KITTITAS COUNTY

DEPARTMENT OF PUBLIC WORKS

MEMORANDUM

TO: All Staff
FROM: Public Works Plan Review Team
DATE: December 20, 2023
SUBJECT: SP-23-00012 KD Properties

KD PROPERTIES SHORT PLAT

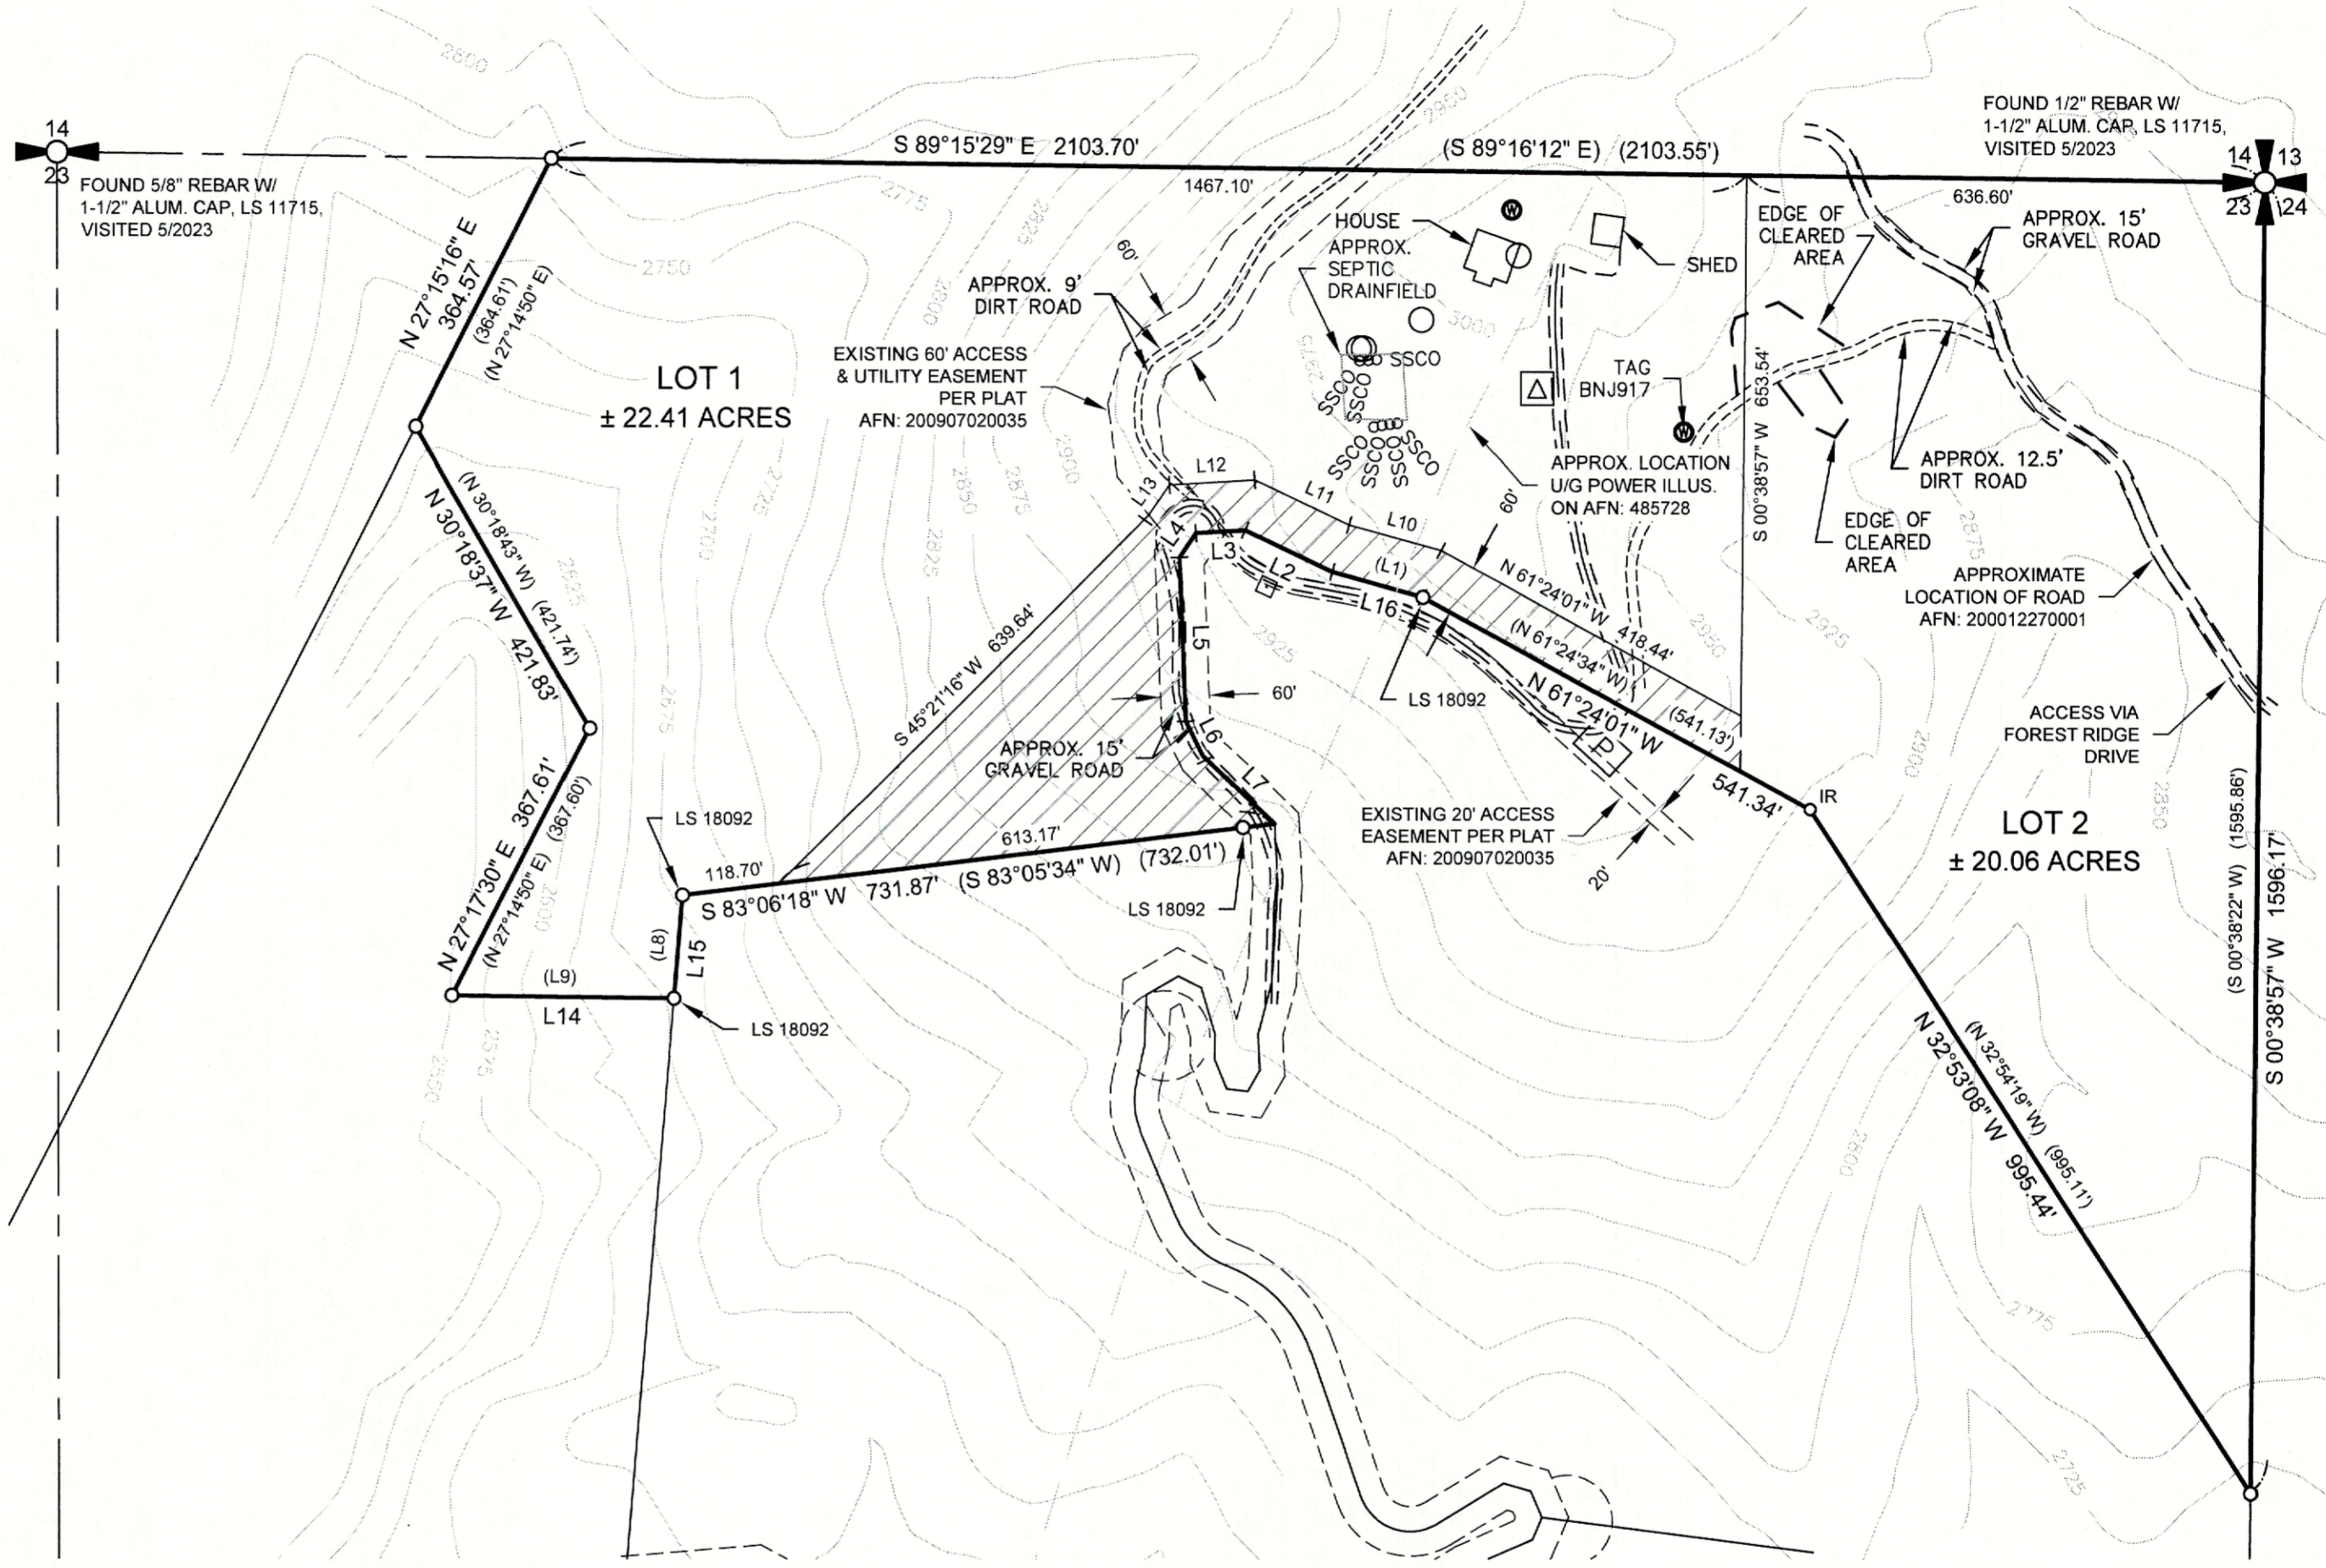
<p>ENGINEERING</p>	<ol style="list-style-type: none"> 1. Except as exempted in Section KCC 14.05.060, no grading or filling upon a site involving more than one hundred (100) cubic yards shall be performed without a grading permit from the County Engineer or Public Works designee (KCC 14.05.050). An application for grading in excess of five hundred (500) cubic yards shall be accompanied by an engineered grading plan (KCC 14.05.080). (JS)
<p>SURVEY</p>	<ol style="list-style-type: none"> 1. The Prelim Short plat does not reference the basis of bearing. 2. The Prelim Short Plat does not meet the requirements of WAC 332-130-145. <p>While not required for Prelim Review, the following elements will need to be addressed for final:</p> <ol style="list-style-type: none"> 3. A title report will need to be provided. 4. The distance to the N1/4 corner of section will need to be shown.

<p>5. The hatched are should be clearly shown as being a portion of Lot 2.</p> <p>6. The corners for the new division line shall be shown on the face of the map, and set in the field.</p> <p>7. Surrounding Plats and surveys should be noted (Sur:16-57 to the North, Plat 14-71 to the East, Survey 36-227 to the South, Survey 31-46 to the West)</p> <p>Of Note (not required) The easement reference per Plat 200907020035, is not centered about the road, nor is it retracable. It is assumed that this is centered about the alignment of Short Plat G-110. It would certainly benefit the public record if the easement as shown included "alignment per SP:G-110" (or similar).</p>
TRANSPORTATION CONCURRENCY	No transportation concurrency comments. (TM)
FLOOD	Parcels 955862 and 960899 are not located in the FEMA identified special flood hazard area (100-year floodplain). (SC)
WATER MITIGATION/ METERING	<p>The following comments outline the requirements for legal availability of water and metering for the proposed short plat:</p> <p>The applicant must provide legal water availability for all new uses on the proposed lots of this project, which can be provided through mitigation certificates. Prior to final plat approval and recording, the following conditions shall be met:</p> <p>In accordance with KCC Chapter 13.35.027, the applicant shall provide one of the following documents before final plat approval:</p> <ol style="list-style-type: none"> 1. A letter from a water purveyor stating that the purveyor has adequate water rights and will provide the necessary water for the new use; 2. An adequate water right for the proposed new use; or 3. A certificate of water budget neutrality from the Department of Ecology or other adequate interest in water rights from a water bank. <p>All applicants for land divisions shall also submit information on "proximate parcels" held in "common ownership" as those terms are defined in WAC 173-539A-030 and otherwise demonstrate how the proposed new use will not violate RCW 90.44.050 as currently existing or hereafter amended.</p> <p>Failure to obtain mitigation before commencement of an activity requiring mitigation shall be a code violation subject to enforcement under Title 18 KCC.</p> <p>Final Plat Notes</p> <p>The following notes shall be placed on the face of the plat:</p>
